Office of
Environment
& Heritage

DOC17/646767-1
SSD6698

Coppabella Wind Farm – Site visit outcomes

Coppabella Wind Farm - Environmental Assessment for Modification One

Coppabella Wind Farm

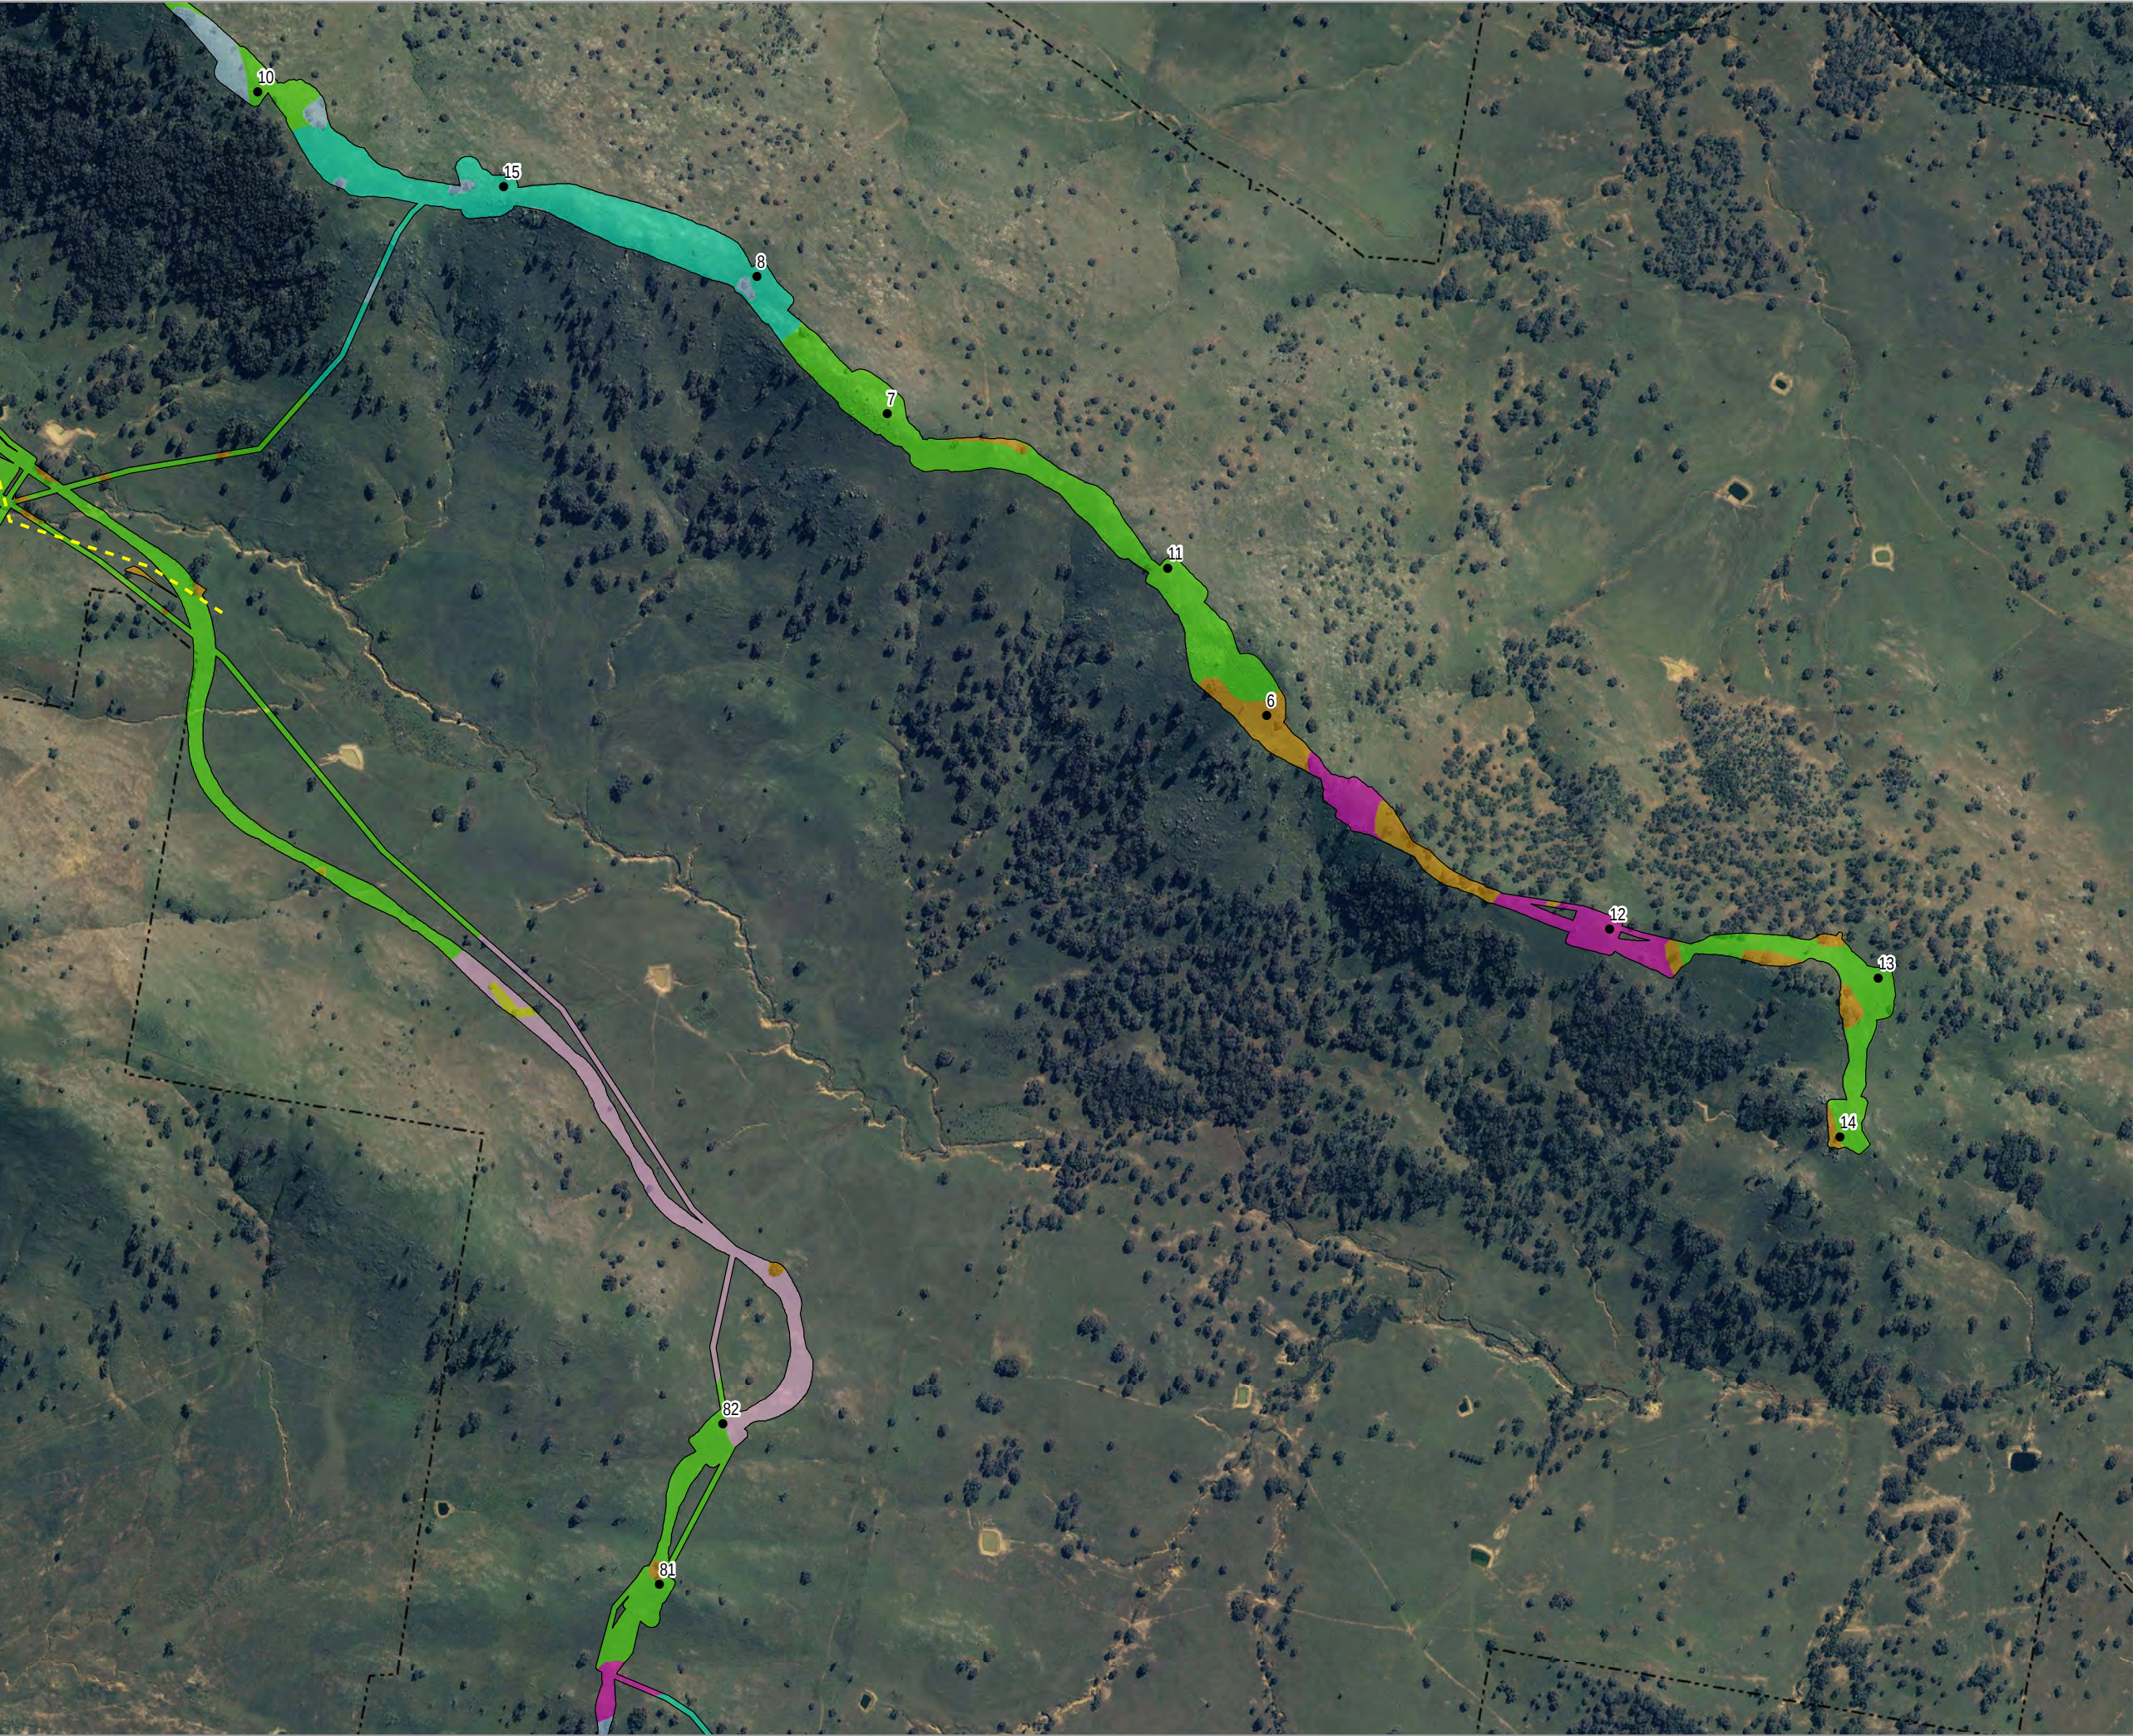
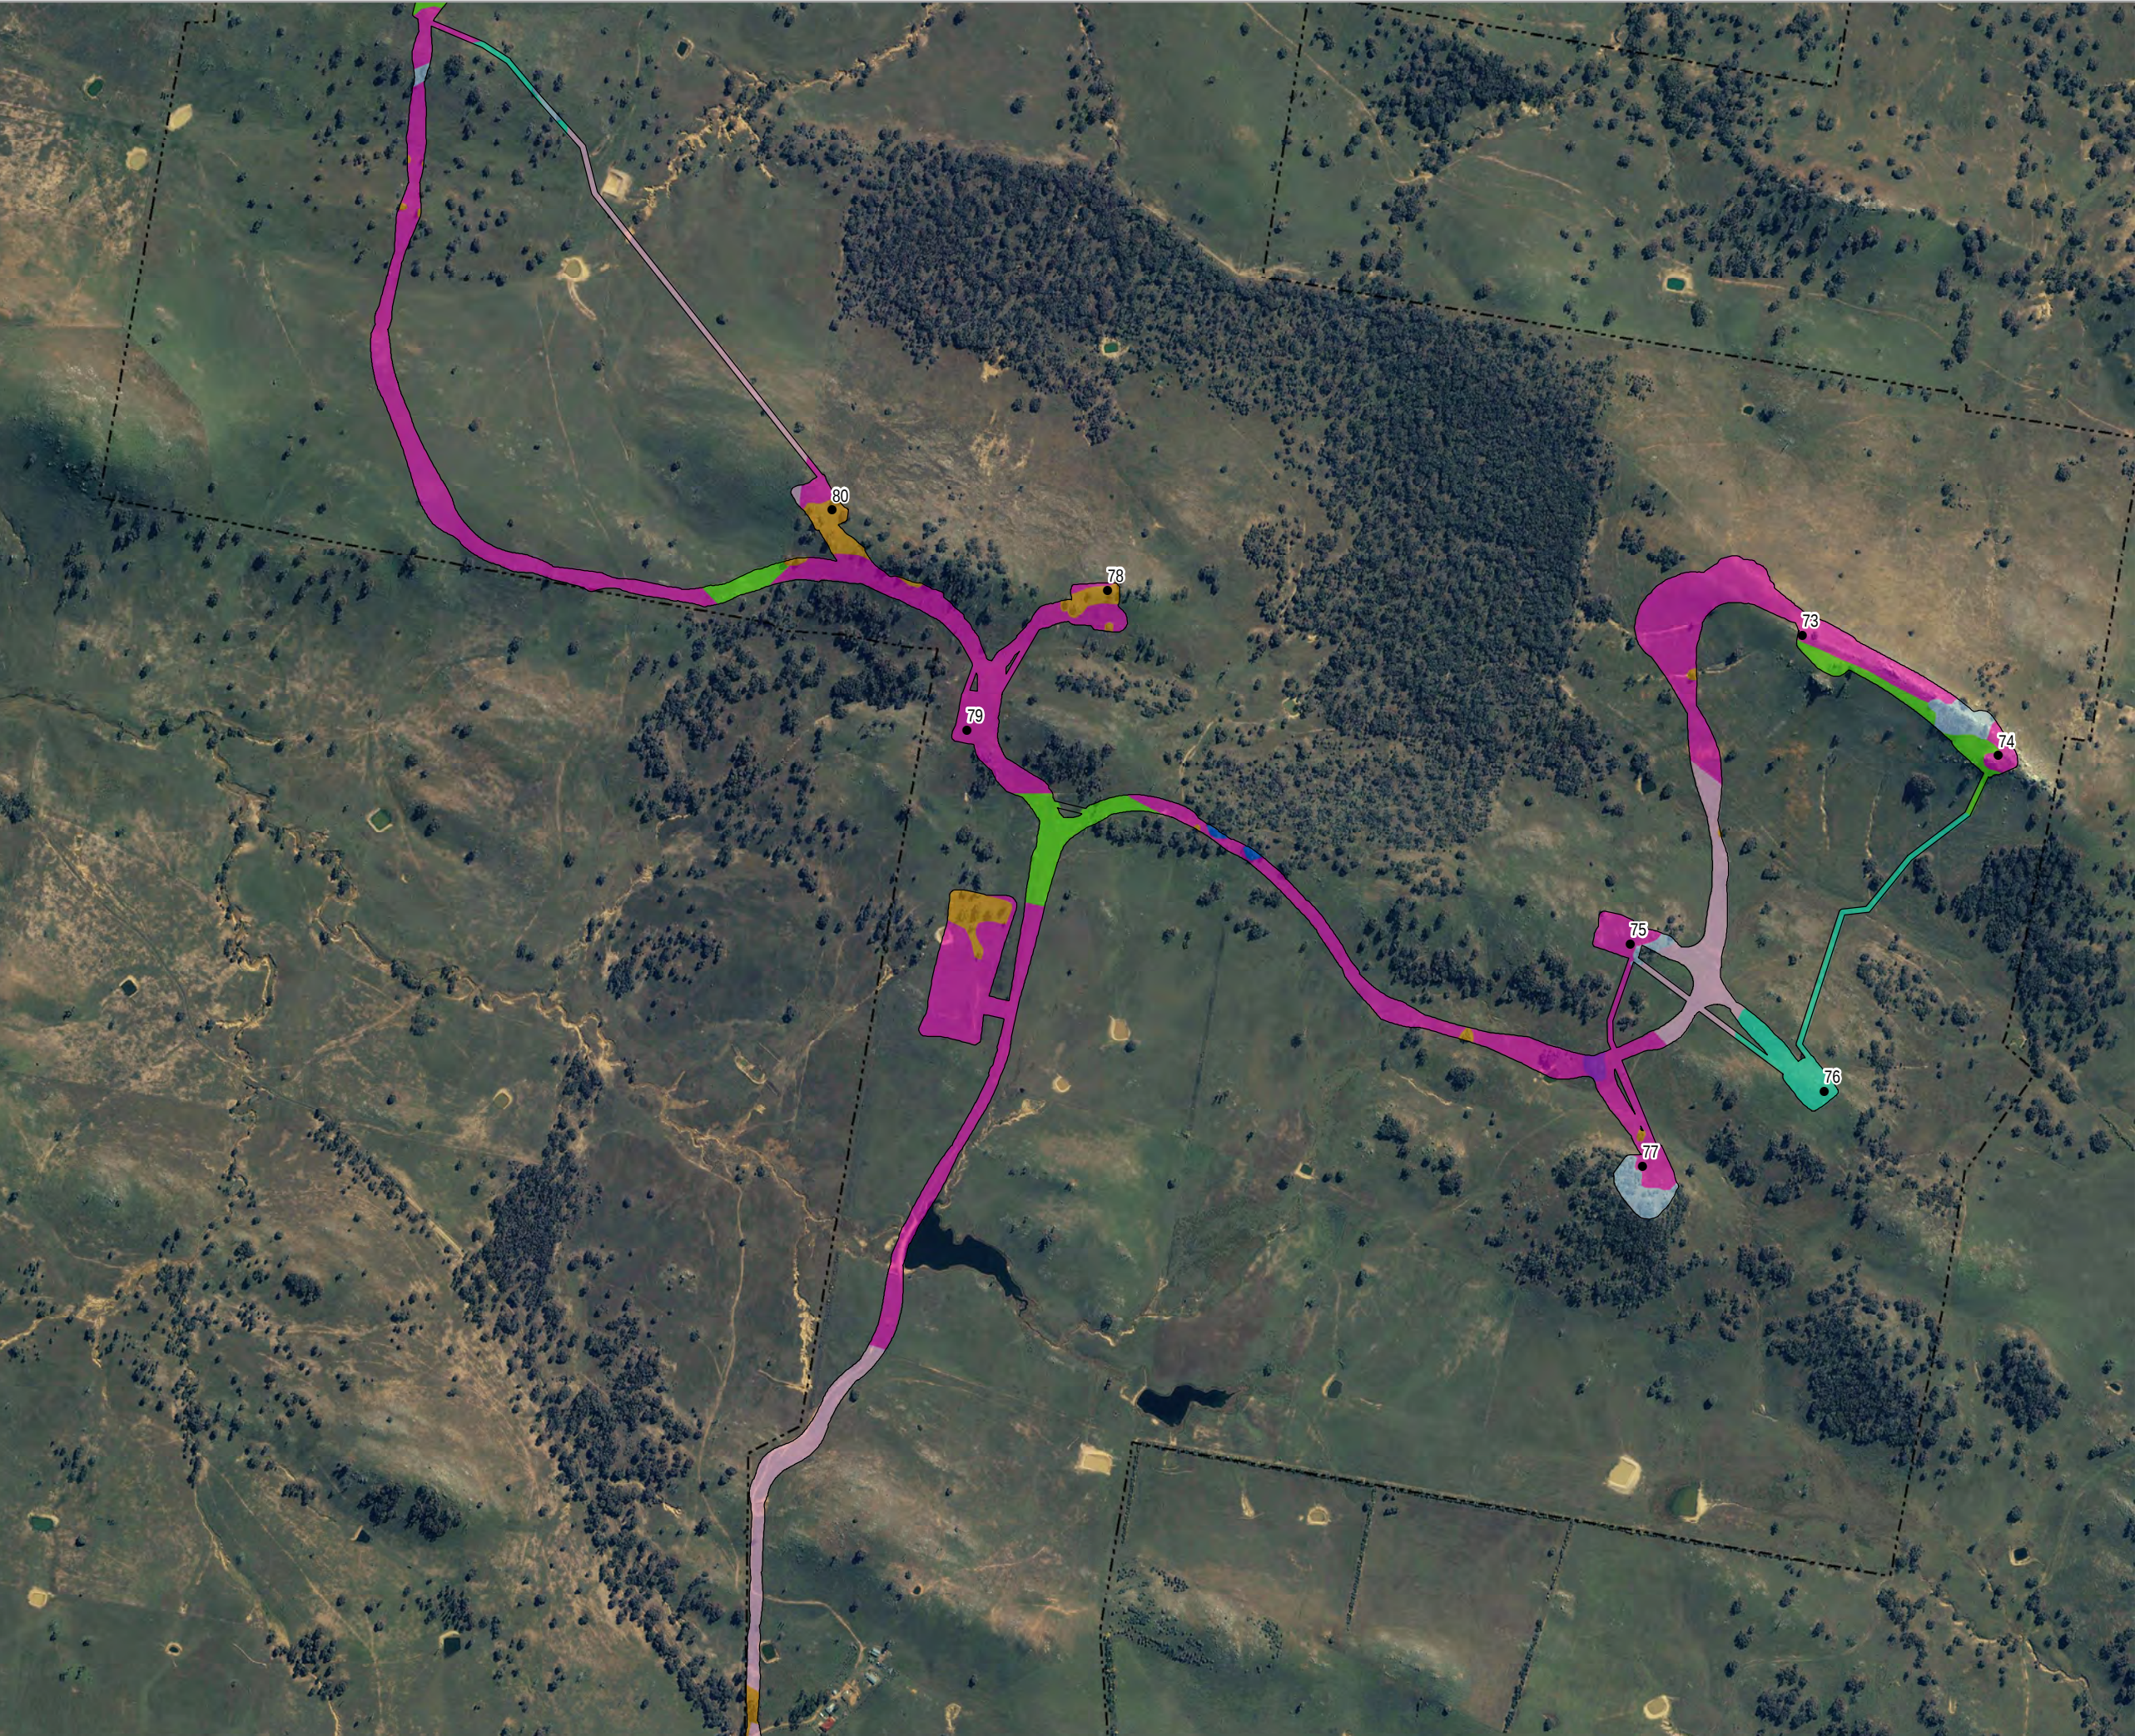
OEH's internal Reference	Easting and Northing GDA94	What the area is currently mapped as	Site inspection finding	OEH's recommended action	Map or photo reference
Photo point FID 3	643560 6151889	Exotic	Confirmed exotic.	None required	n/a
Photo point FID 4	643630 6152117	Exotic	Confirmed exotic.	None required	n/a
Photo point FID 7 – to FID 10	644242 6154023 To 644470 6153861	Exotic	This area is the Box Gum Woodland derived native grassland. NGH agreed on site.	change mapping in this area to Box Gum Woodland derived native grassland (EEC).	Area mapped on Map 1 below.
Photo point FID 13	642206 6154029	This area is mostly mapped as exotic, with small sections of Box Gum woodland - Moderate to good (low) mapped where the trees are.	The trees are close enough to mean the whole area should be mapped as the Box Gum Woodland vegetation moderate to good – the groundcover is also native (not exotic). There is a substantial Yellow Box tree with hollows in this area that should be protected during construction and operation.	Update mapping of this area to Box Gum Woodland (EEC) - moderate to good condition. Move infrastructure into the more degraded areas.	Area mapped on Map 2 below.

Photo point FID 15	641768 6154245	Exotic	Confirmed exotic.	None required	n/a
Photo point FID 16	641811 6154561	Box Gum woodland - Moderate to good (low) and mix of other.	Infrastructure placed in an area mapped Box Gum woodland - Moderate to good – when there are exotic	Suggest avoiding impact to the Box Gum woodland – EEC and situating the infrastructure in a cleared area.	Area mapped on Map 3 below.

cleared areas surrounding it.		
Observation point FID 2	641712 6154573	Exotic	Over 50% native. This area is the Box Gum Woodland derived native grassland. NGH agreed on site.	Update mapping in this area to Box Gum Woodland derived native grassland (EEC) - Moderate to good condition	Area mapped on Map 4 below.
Observation point FID 3	641685 6154576	Box Gum Woodland derived native grassland - low (exotic)	Over 50% native. Box Gum Woodland derived native grassland - Moderate to good	Update mapping in this area to Box Gum Woodland derived native grassland (EEC) - Moderate to good condition	Area mapped on Map 4 below.
Observation point FID 4	641390 6154488	Box Gum Woodland derived native grassland - low (exotic)	Over 50% native. Box Gum Woodland derived native grassland - Moderate to good	Update mapping in this area to Box Gum Woodland derived native grassland (EEC) - Moderate to good.	Area mapped on Map 5 below.

Observation point FID 5	641271 6154734	Box Gum Woodland derived native grassland - low (exotic)	Over 50% native. Box Gum Woodland derived native grassland - Moderate to good	Update mapping in this area to Box Gum Woodland derived native grassland (EEC) - Moderate to good	Area mapped on Map 6 below.
Observation point FID 6	642170 6155321	Exotic	Confirmed exotic.	None required	n/a
Observation point FID 7	640898 6155370	Box Gum woodland - Moderate to good (low)	Likely to meet a higher quality class – very good quality vegetation in this area with a very high number of tree hollows. Sighting of two Wedged-tail Eagles foraging in this area.	Avoid this area of important woodland – moving infrastructure to areas of degraded vegetation surrounding this patch.	Area mapped on Map 7 below.
Photo FID 18	636829 6155380	Exotic	Confirmed exotic.	None required	n/a
Photo FID 19 & 20	638515 6154116	Exotic	Borderline exotic and native. Difficult to tell due to grazing pressure.	None required	n/a
